Woolworths Customer Fulfillment Centre (CFC), 74 Edinburgh Road, Marrickville - Response to Department of Planning Queries

This letter has been prepared to address comments on the submitted *SSDA Acoustic Assessment* (ref: 20200376.1/0906A/R5/WY, dated 9/06/2021) and *Preliminary Construction Noise & Vibration Management Plan* (ref: 20200376.2/1510A/R1/WY, dated 15/10/2020) in relation to the proposed Woolworths Customer Fulfillment Centre at 74 Edinburgh Road, Marrickville (ref: 20200376.1/0906A/R5/WY, dated 9/06/2021). The comments are detailed in an email from Patrick Copas dated 19/08/2021 and a *Request for Additional Information* letter, dated 7 September 2021.

Figure 4 – Overall 2D View, Grid Noise Map at 1.5m

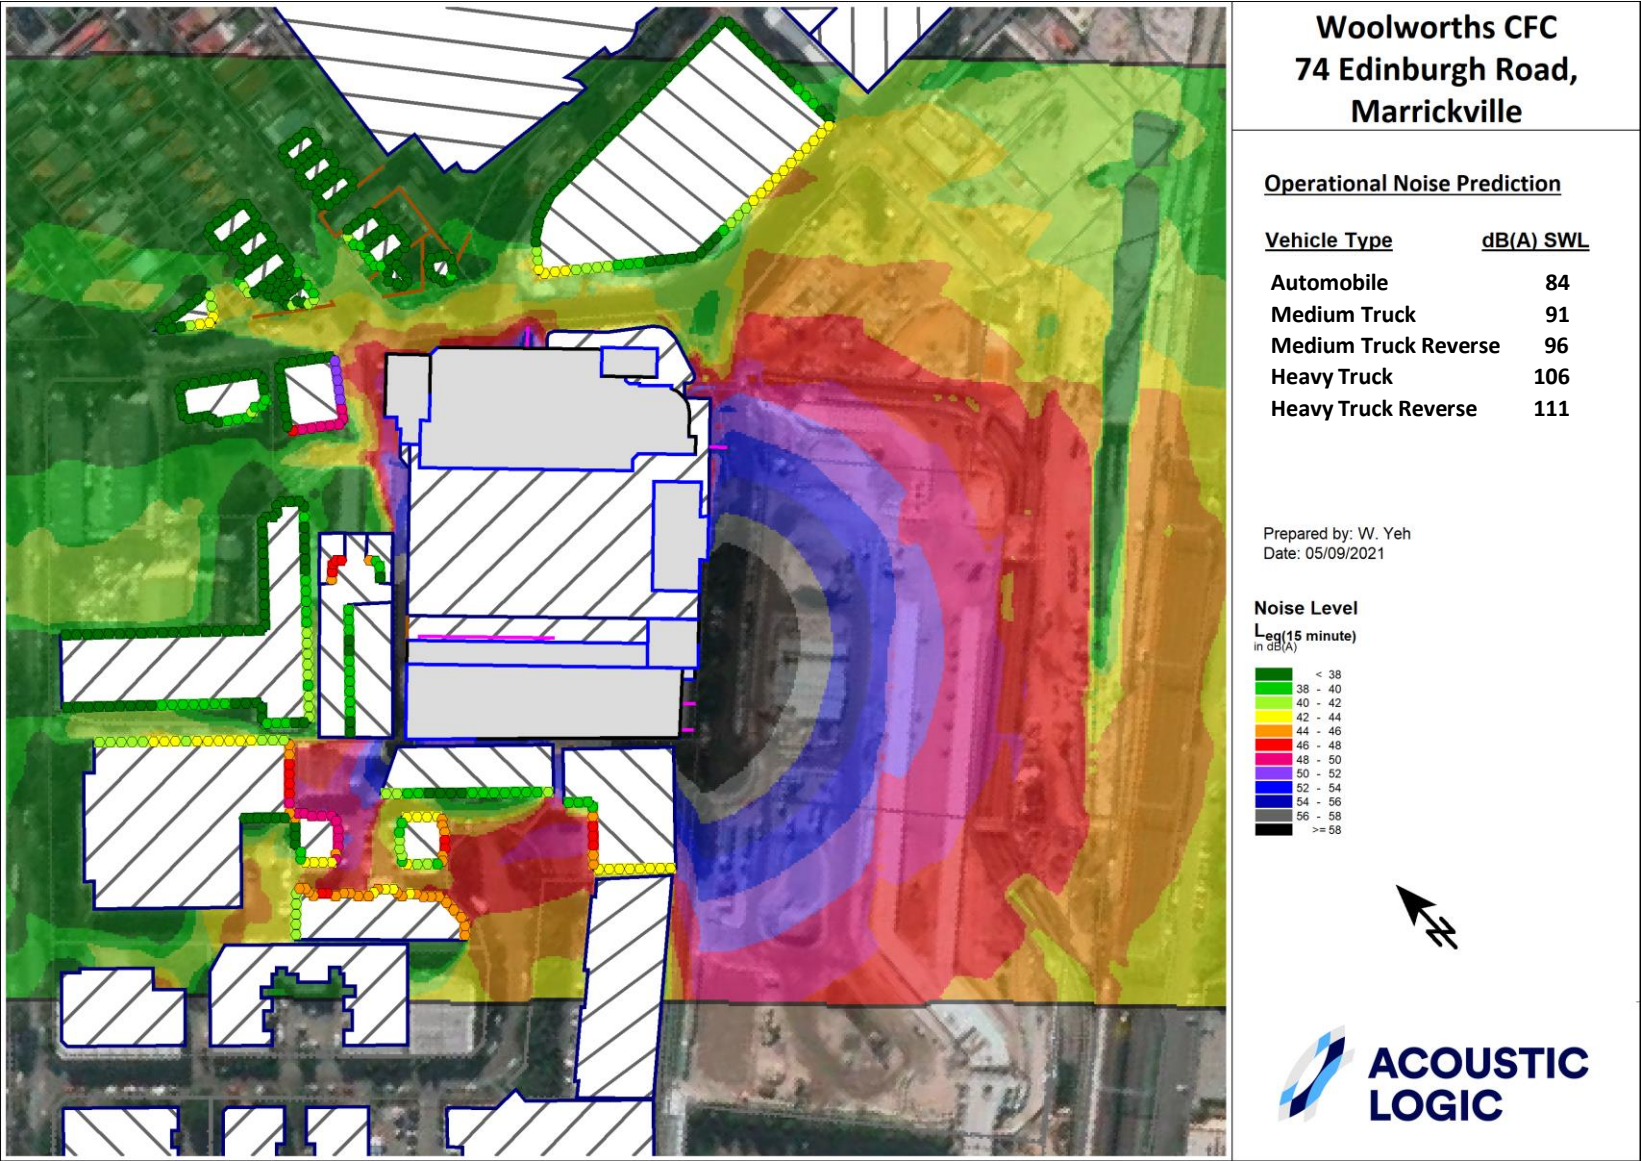
The colour scale used on figures 4 to 11 varies slightly. Please update these figures to maintain a consistent colour scale.

Figures 4 and 9 show a large building on the Sydney Metro site, which was demolished in early 2020. Please update these figures accordingly.

Figures 4 & 5 provide overall grid noise maps for the site, and demonstrate noise propagation from the site over differing areas. Given the wider area covered in Figure 4, a more restricted colour scale would not demonstrate sufficient detail to describe predicted noise levels. Figure 5 provides a more detailed map of noise contours for residents to the north (being the closest residential receivers).

The modelling has been updated to reflect this change. Refer Figures 4-12.
